Land East of J11, M40, Banbury Supplementary Environmental Information Volume 2: Appendices

Land East of Junction 11 of the M40, Banbury

Transport Assessment Addendum

26th October 2022
SJT/RT/23457-06f Transport Assessment Addendum

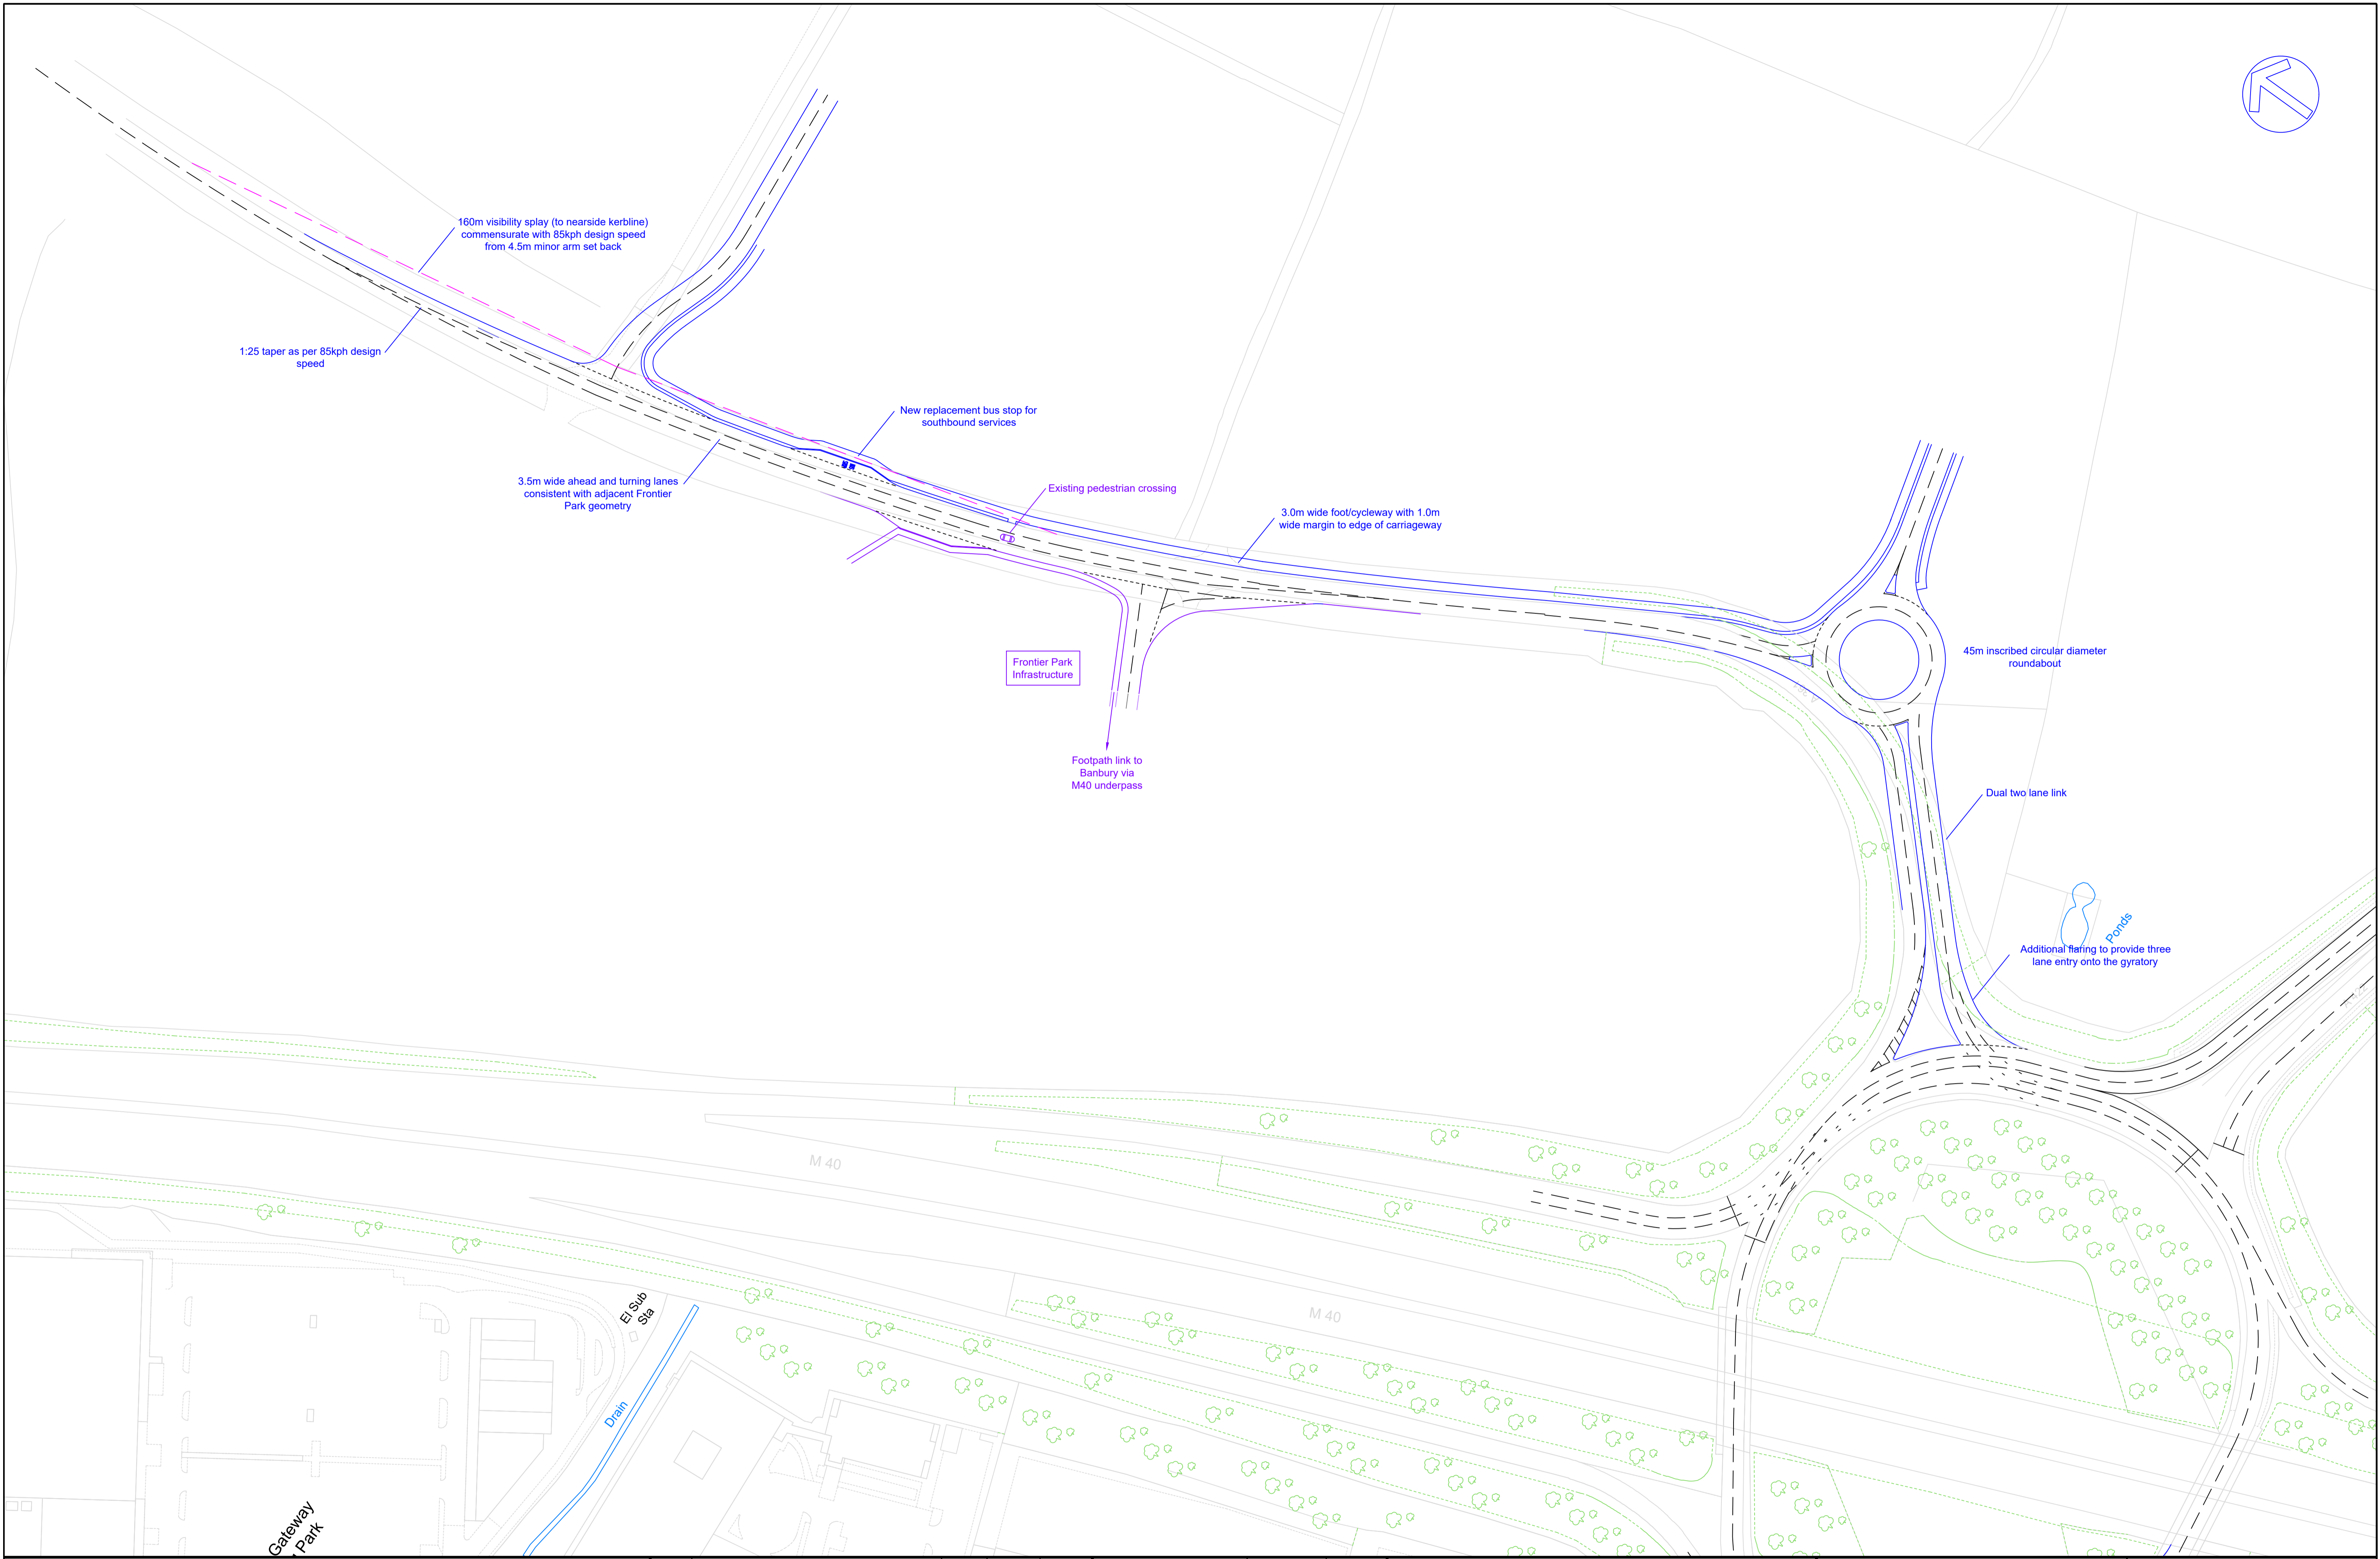
The primary access would be a three-arm roundabout located just a little over 100m from the A361 exit on to the Junction 11 roundabout. This proximity is likely to cause occasional severe congestion issues and is a reason for objection. See further discussion below under Traffic Impact. It has not been demonstrated that there is sufficient distance to accommodate the necessary direction signage.

As the walking route would entail crossing the busy A361, a signalised crossing will be required, on the desire line between Frontier Park and the site access, to ensure pedestrian safety along the only available route.

- 4.1 The site access junction has been located to remove a tight horizontal curve through which forward visibility below desirable minimum for the posted speed limit is not achievable within highway land. As set out below queue lengths without the development are forecast to increase significantly in the future with interaction with the substandard bend more likely in the future. Removal of the bend and replacement with a roundabout will make the legibility of the arrangement and queue patterns materially better which is positive from a road safety perspective.

- 4.2 The A361 South entry onto the proposed roundabout has a maximum unopposed capacity of (intercept) of 2,267 PCU/hr. The forecast future year demand (base + committed development + development demands) is slightly more than 1,000 PCU/hr. The maximum effective exit flow from M40 Junction 11 onto A361 will be circa 1,500 PCU/hr i.e., the critical flow at the upstream node where all the flow from northern motorway overbridge is routing to the A361 exit (this is unlikely to happen). Even accounting for unequal lane usage, A361 ahead traffic will use the nearside lane only, the site access roundabout would not act as a bottleneck in day-to-day operation. This is demonstrated in the LINSIG and ARCADY modelling and will be further confirmed through VISSIM runs.

- 4.3 With respect to signage, there will in the future still be a single exit lane from the motorway junction gyratory. It is unlikely that the site itself warrant explicit signing from the downstream junction. Traffic to the site will in effect bifurcate from the ahead traffic into effectively a dedicated lane to the development site. Road markings would suffice however directional signage could be provided in the nearside verge at the decision point.

- 5.4 A signalised crossing can be provided as part of the proposed development.

FIGURE 5: ILLUSTRATIVE SITE LAYOUT

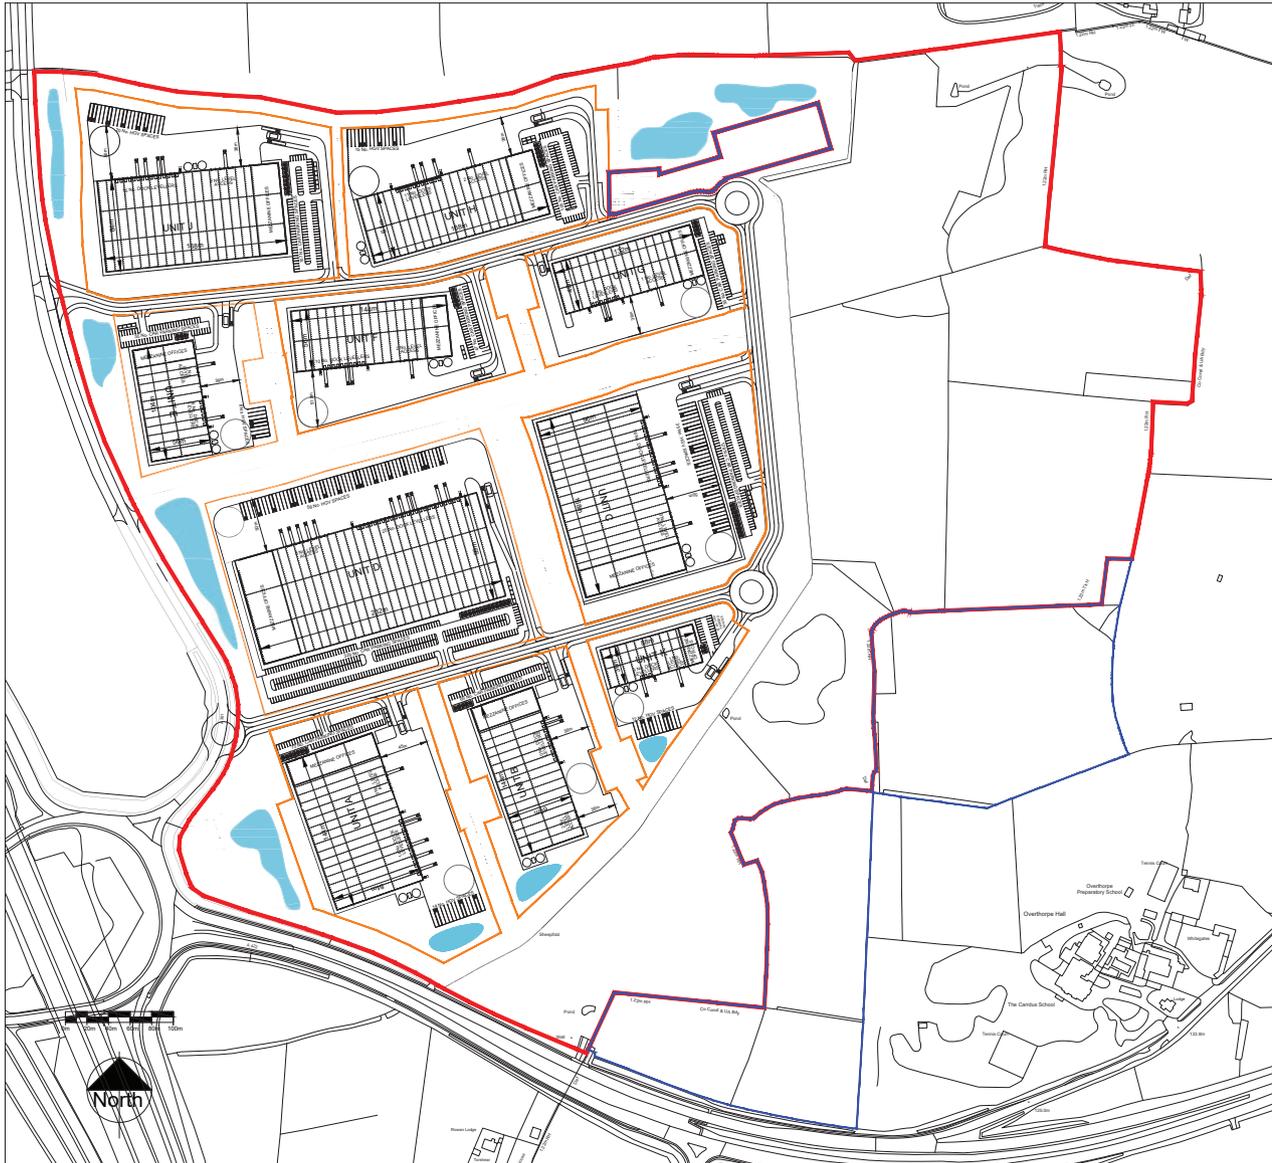
Final layout of the development will be determined at the Reserved Matters stage. However, the design shown in the Illustrative Site Layout drawing (no. 05001 Rev. P8) is unlikely to be acceptable.

The internal street layout is simple, with each industrial unit being accessed directly from the distributor road which terminates at the primary and secondary access points. All footways must be 2.0m wide and car parking spaces at least 5.0m x 2.5m.

The Site Layout shows the road leading from the primary access to be a straight length of 460m, and directly serving only three of the ten Units. Many vehicles will therefore be travelling the full length, so are likely to do so at speed if not calmed somehow. Deviations or features are typically placed at a maximum spacing of 70m to reduce speeds. All three links of the distributor road have excessive straight lengths so a major adjustment to the road layout will be necessary before it may be considered acceptable.

An internal network of pedestrian and cycle paths should be incorporated to keep active travellers clear of the road network and to encourage these modes of transport. The network should emerge on the A361 at the location of the signalised crossing (to be provided by this development).

- 7.1 The internal access roads will not be adopted, and residential design principles are unlikely to be appropriate on a commercial site that must accommodate large commercial vehicles particularly taking into account that the Government is actively considering allowing larger commercial vehicles on the road network up to 25m. The requirements for the internal layout of the site can be achieved through a condition if demonstrably necessary, but as identified by OCC the site layout at present is illustrative as the application is in outline.
